DECISION DELEGATED TO HEAD OF PLANNING

Application No: H05-1070-21 **Applicant:** Seagate Homes (UK) Ltd.

Proposal: Proposed development comprising 2 houses (including new vehicular access off Fleet Road)

Location: Land North Of Holbeach Manor Fleet Road Fleet

Block Plan - HOLBEACH MANOR
NOT TO SCALE. 26.11.21.

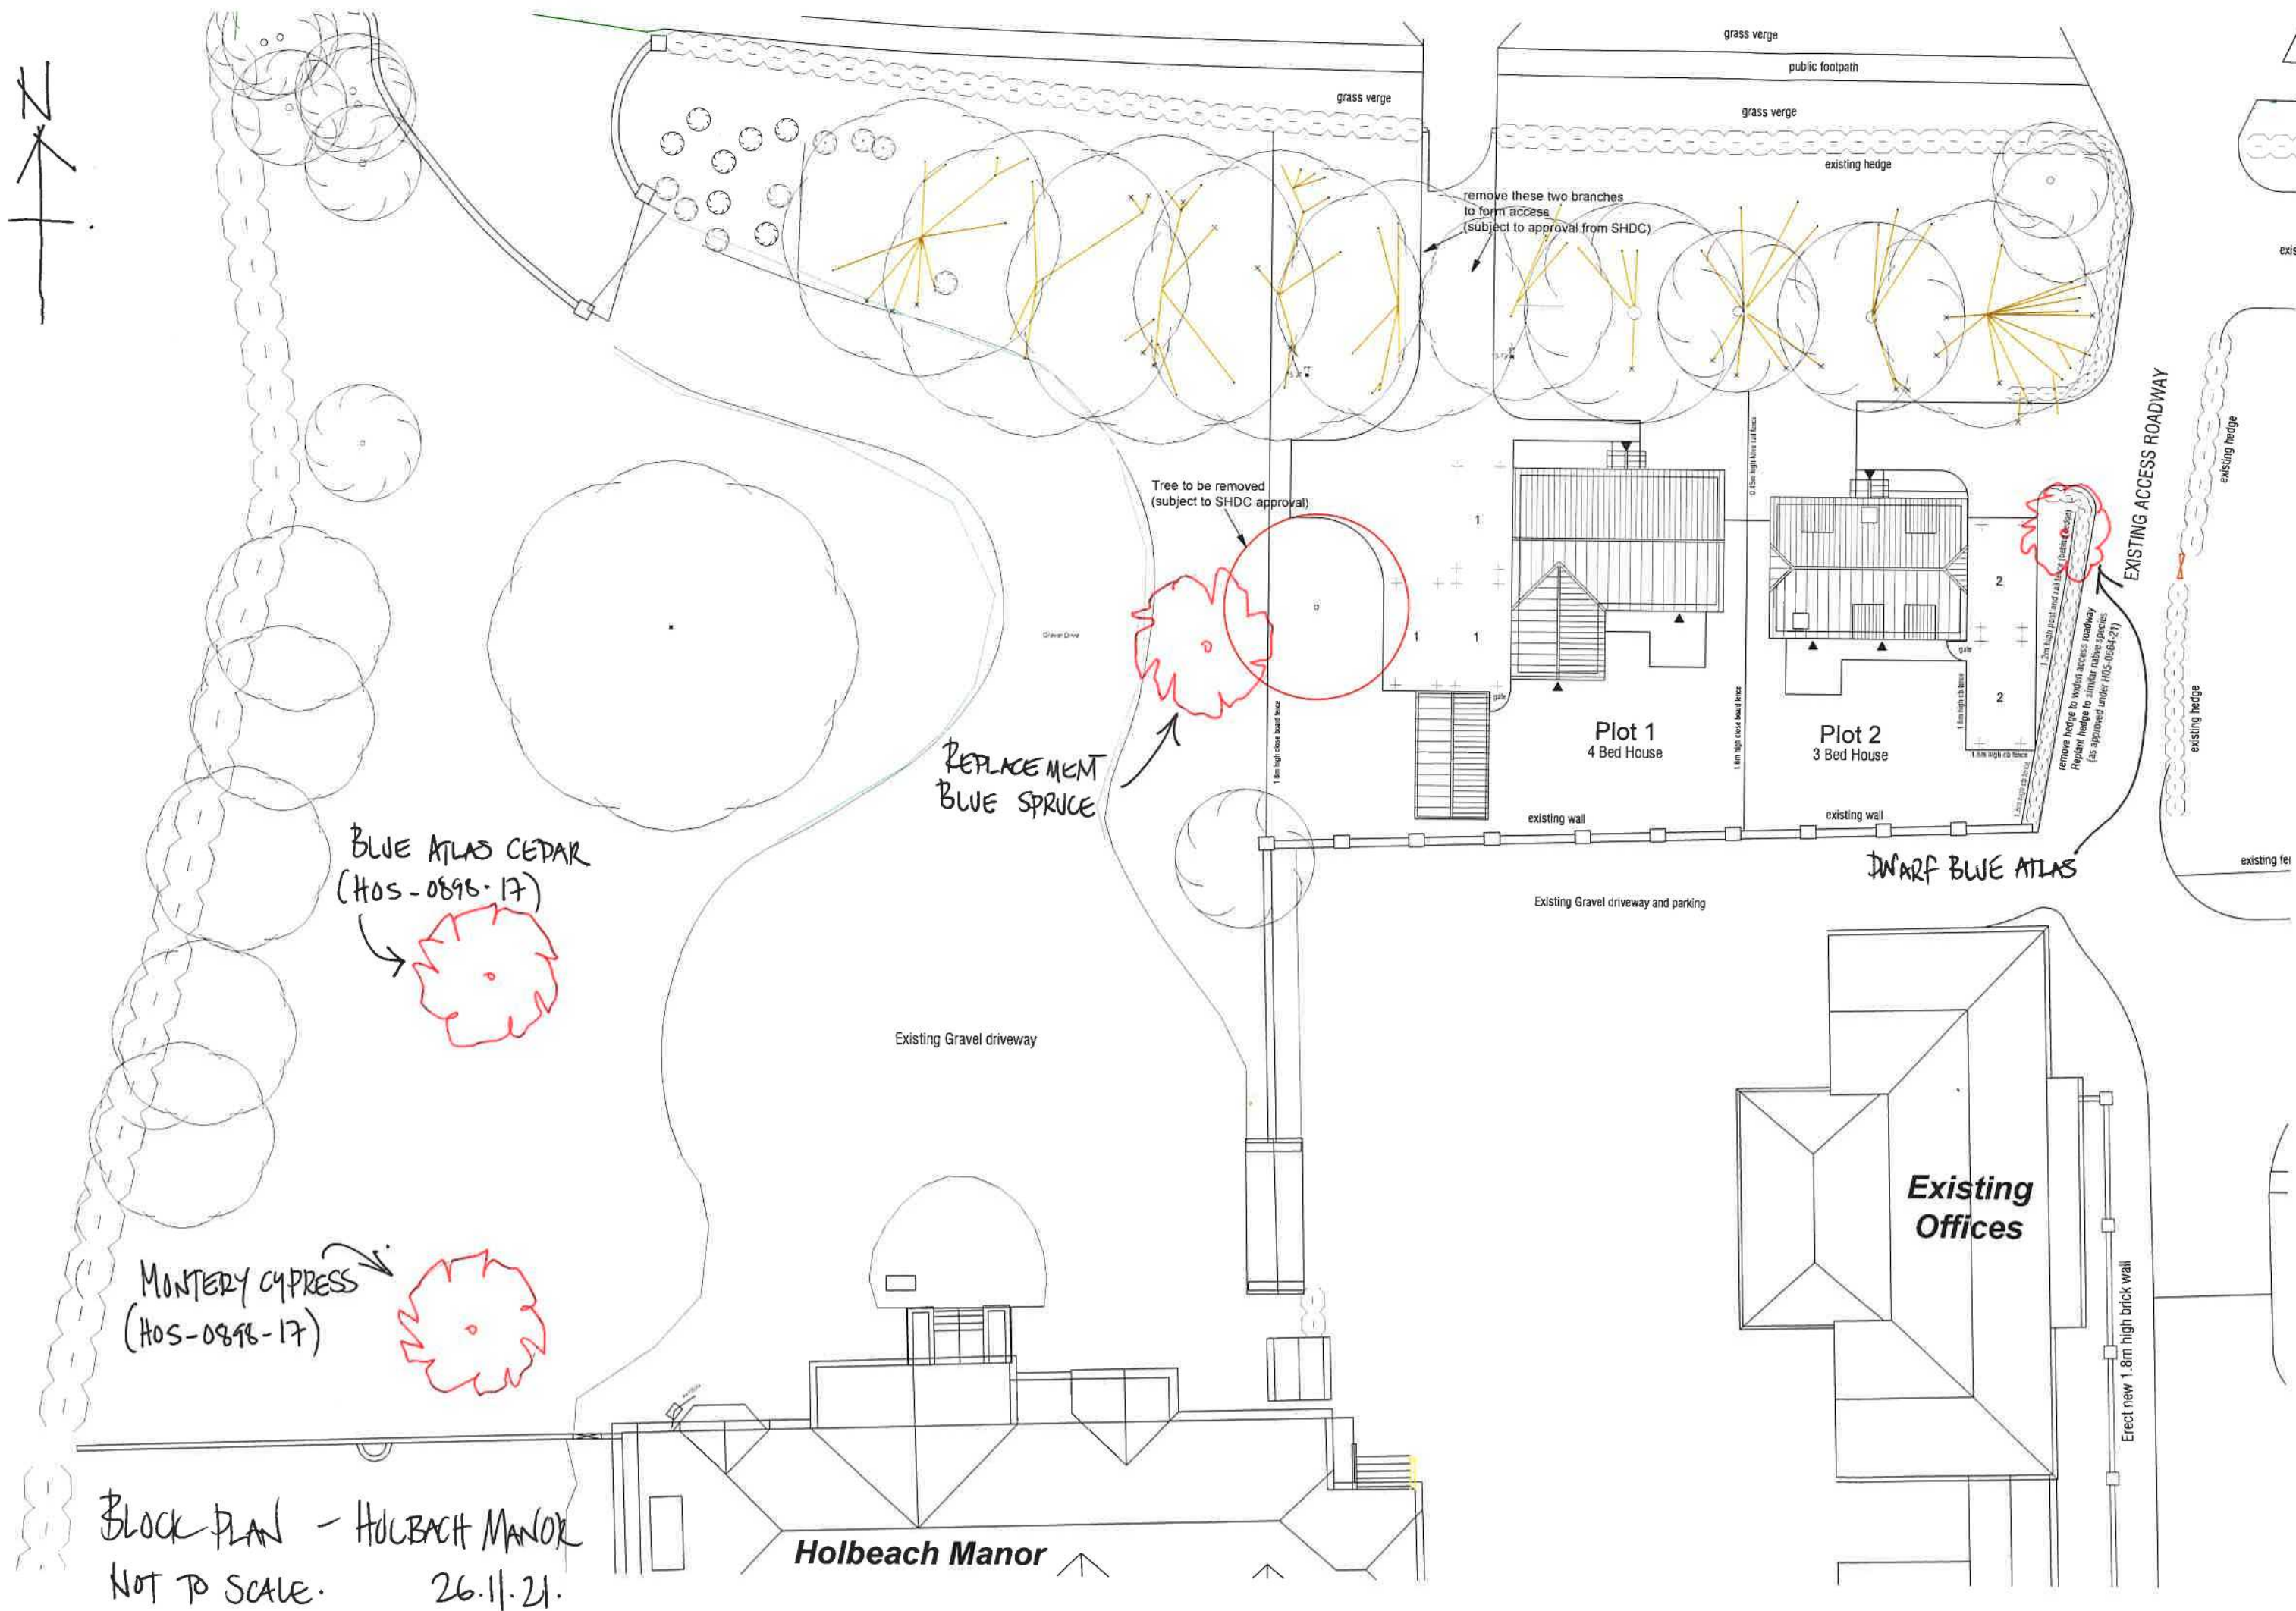
SHDC Tree and Nature Conservation Officer - Raises concern re building within the Root Protection Areas of the frontage trees and the potential for future occupants to seek the removal of these trees. The minute front gardens of the properties will be dry due to them being totally within the Root Protection Area of the western red cedar trees. Any attempt at cultivation of the frontage gardens will result in on-going damage of feeder roots of the trees.

The proposed development would result in the loss of three trees, one of which is protected by virtue of Tree Preservation Order ref. TPO-05B-01-1987 (the Spruce at the western side of the site). No objections are raised to the removal of the latter however, given its poor condition and it is

SHDC's Tree and Nature Conservation Officer has also highlighted that two replacement trees that should have been planted in association with application ref. H05-0898-17 have not yet been planted. The applicant has subsequently revised the Site Location Plan to indicate where the replacements will be planted, and given that they fall within the blue line, this can be conditioned.

Concern has been raised regarding building within the Root Protection Areas of the frontage trees and the potential for future occupants to seek the removal of these trees. The two properties have now been positioned slightly further back to create a greater distance to the trees.

showing dieback. A replacement blue spruce is indicated just outside of the red line boundary.

Conditions can also be added to ensure that appropriate protection is afforded to the remaining trees during the construction process and that no-dig construction is used where relevant.
